File No: R/2016/1/A
Our Ref: 2016/630380

MP 08_0098 – Alterations and Additions to The Star Casino Complex and New Hotel on former Switching Station – MOD 14

The City of Sydney (the City) has had the opportunity to review the Applicant's Environmental Assessment for proposed MOD 14 to Part 3A approval MP 08_0098.

1 ASL-LEVEL 00\_SELS BUILDING VIP DEPARTURE  
A21000 1:50

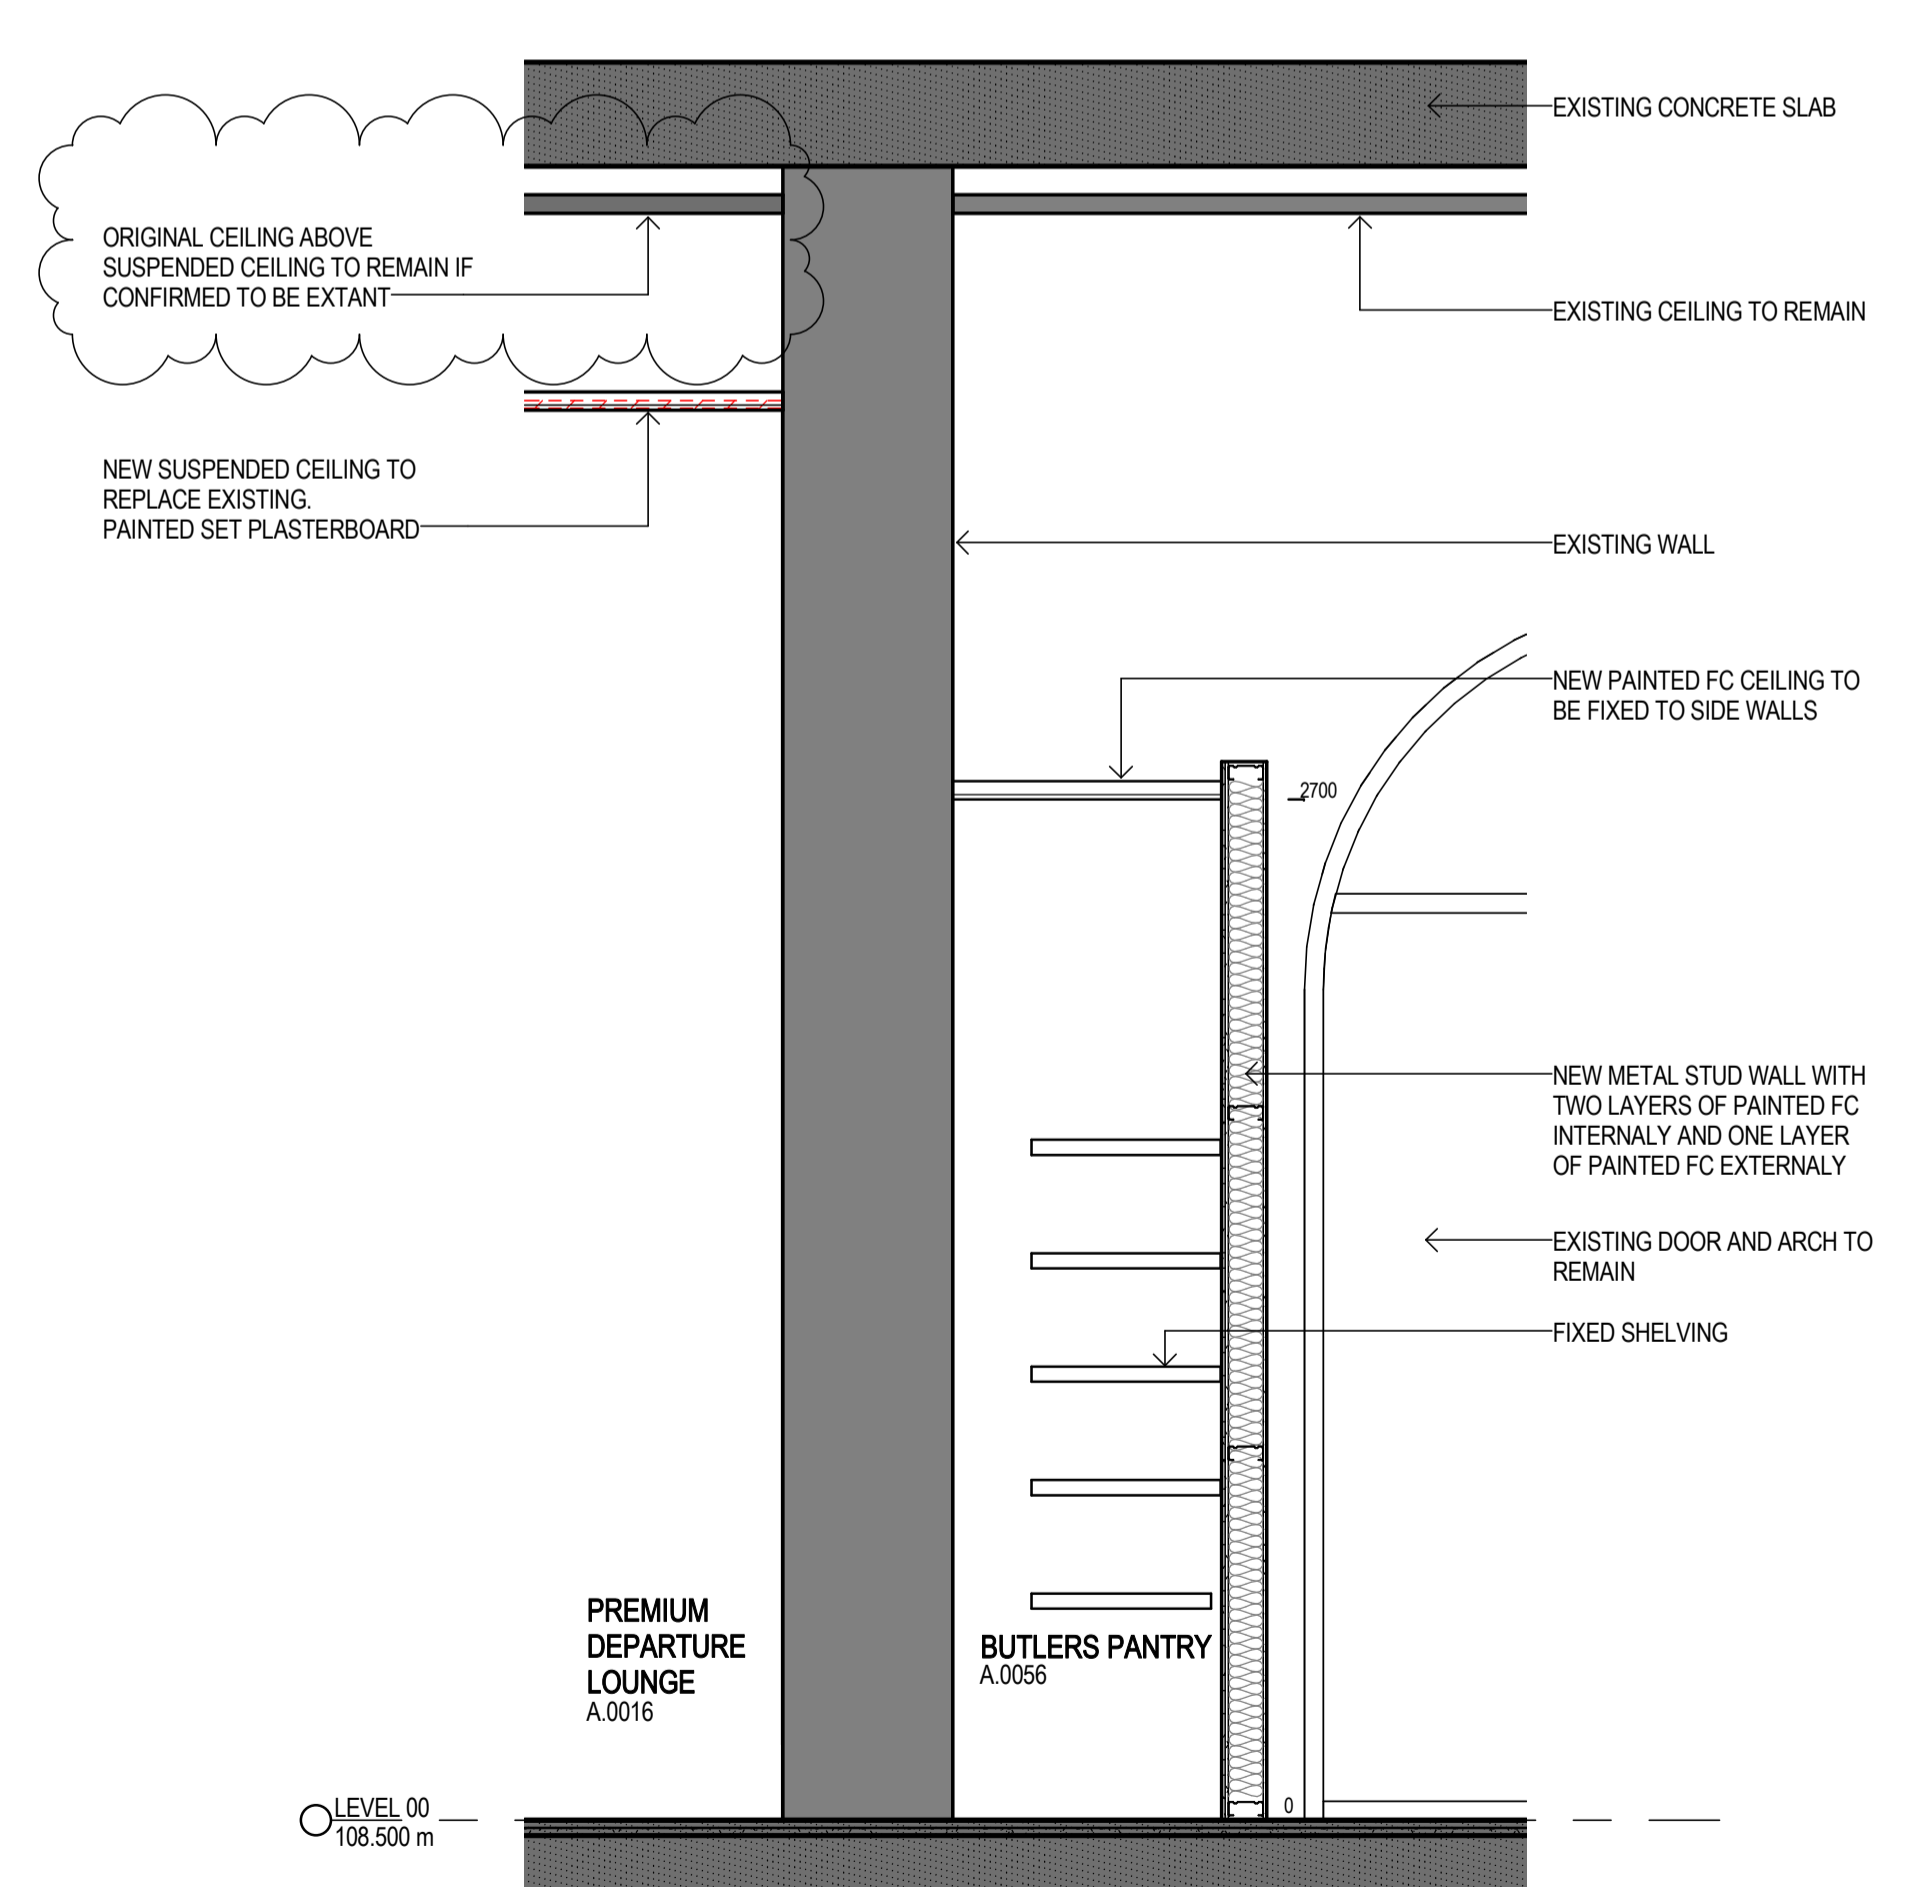
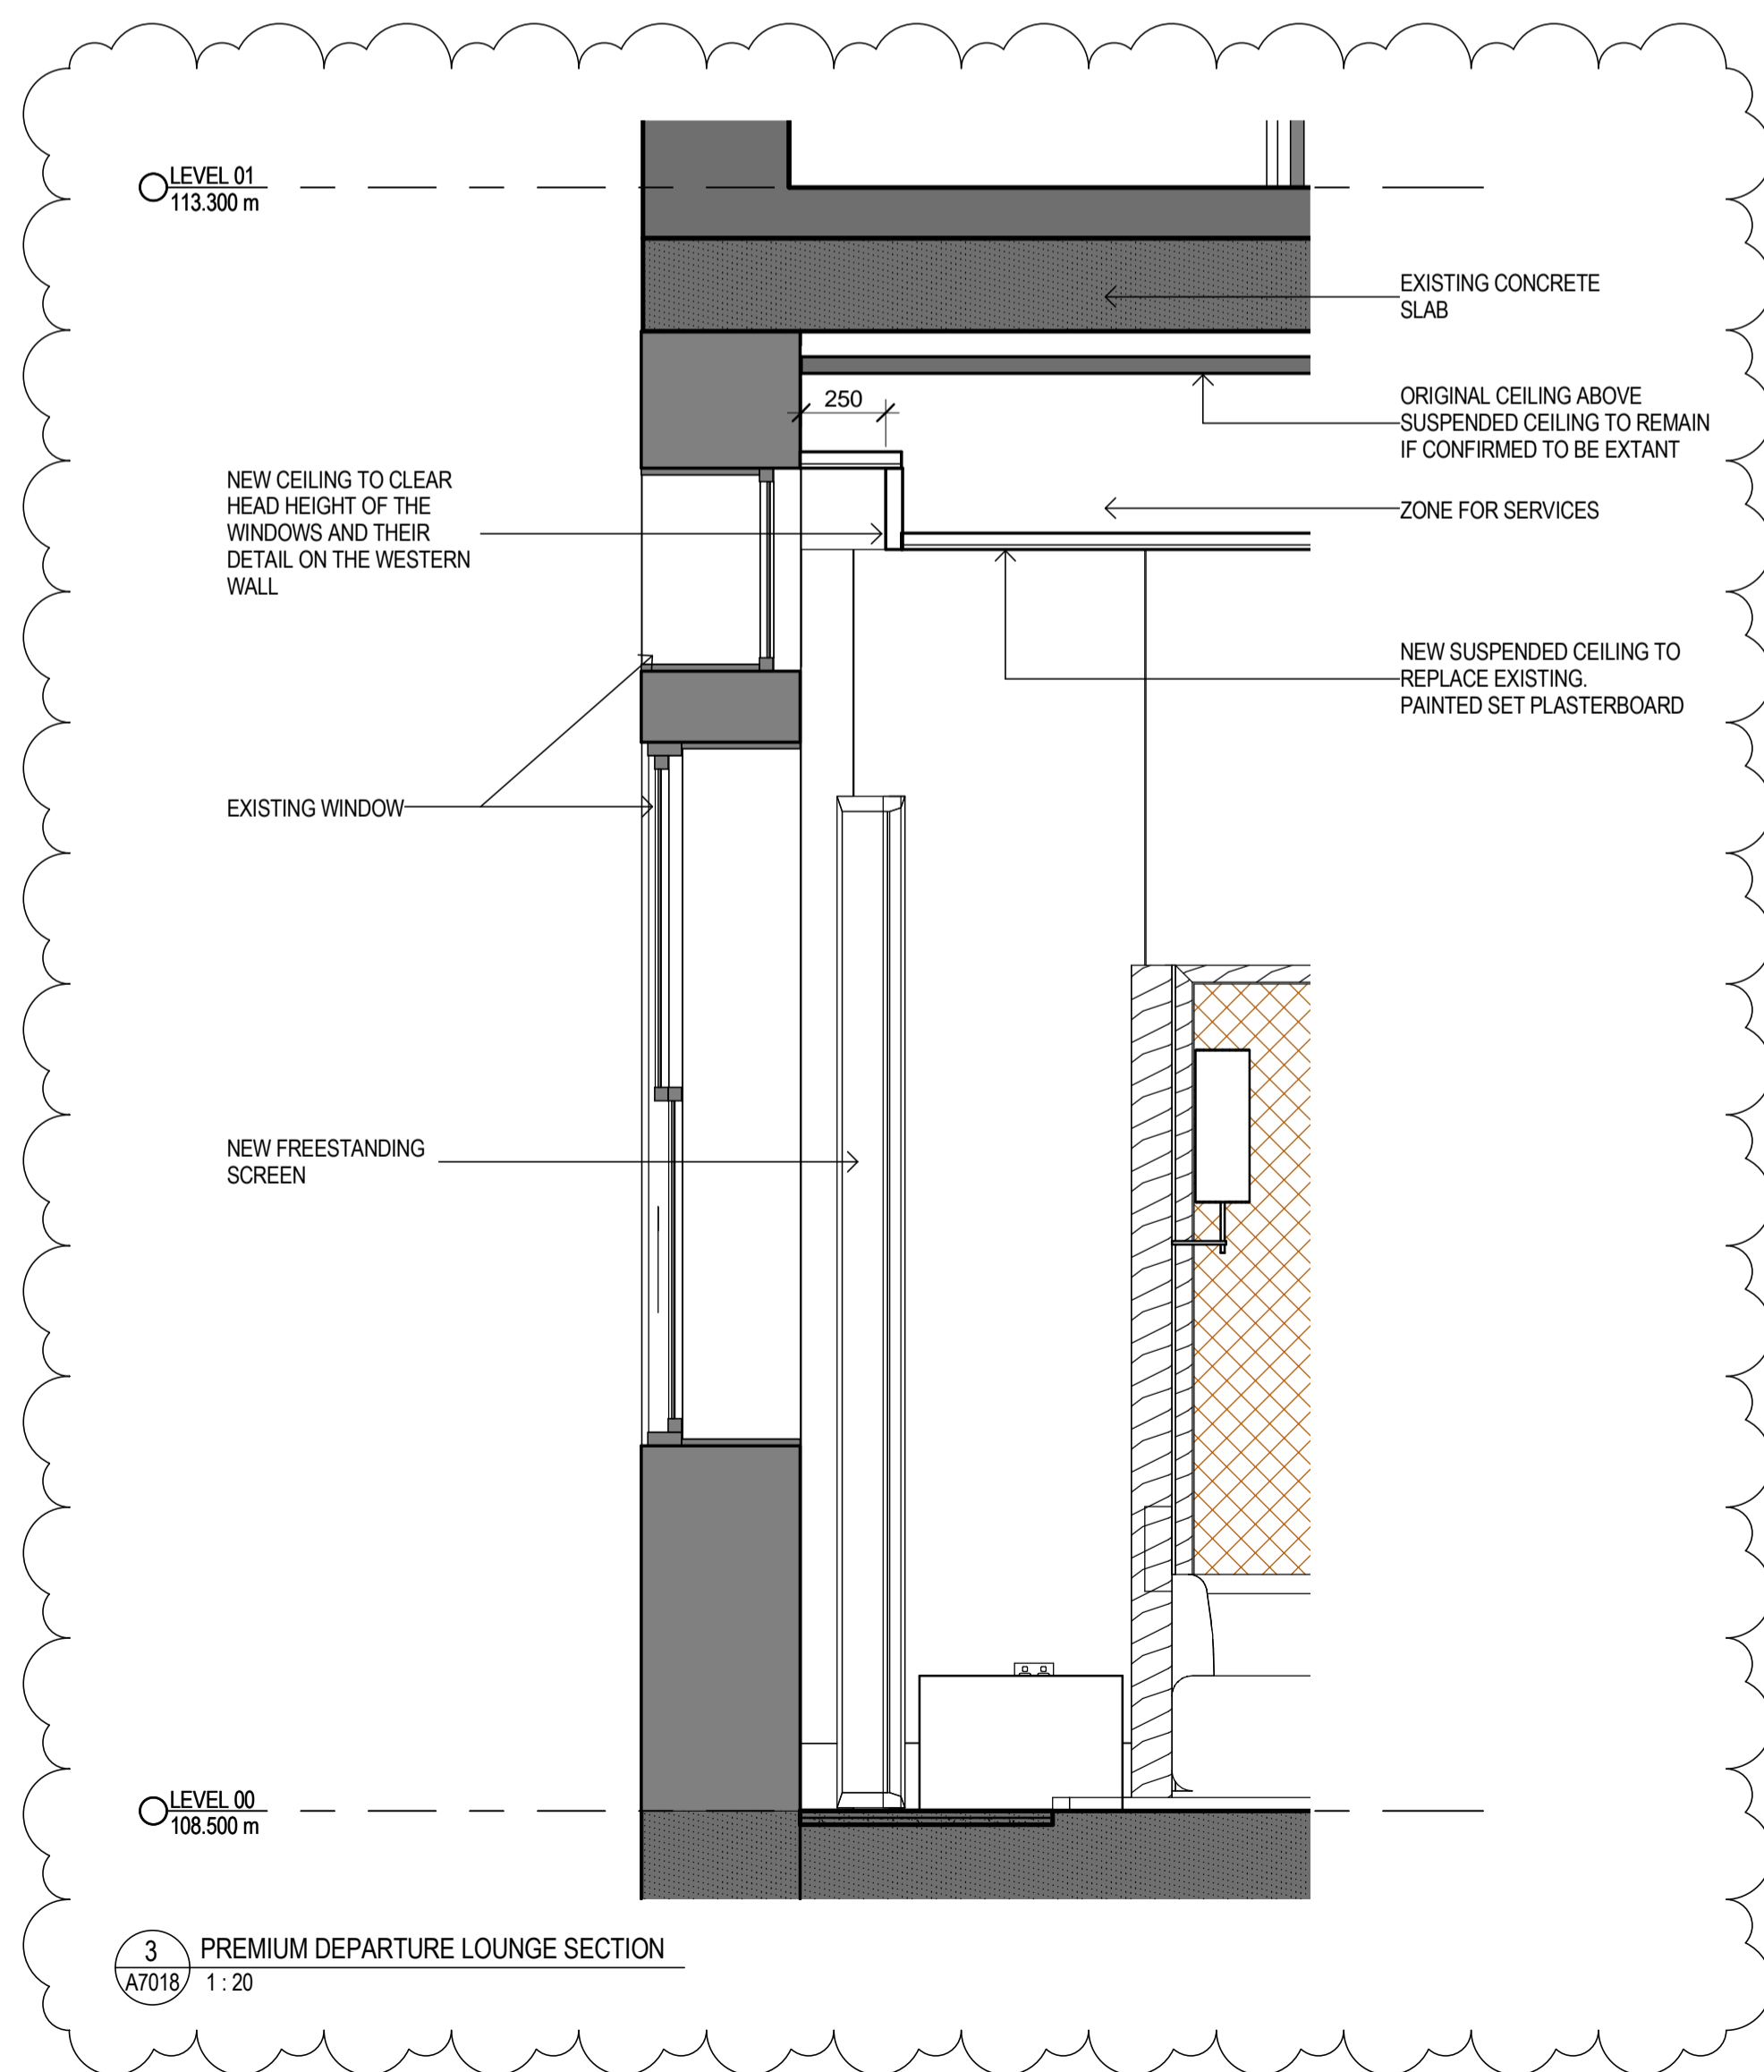
With regard to the arrival lounge, the demolition plan is unreadable and the proposed changes are difficult to decipher. Clear details of the demolition and the changes being proposed should be shown on the drawings, including sections, which should include the extent of demolition, lightweight construction of the new partition for the butler’s pantry and other changes to the room layout, removal of the suspended ceiling, details of screening, etc.
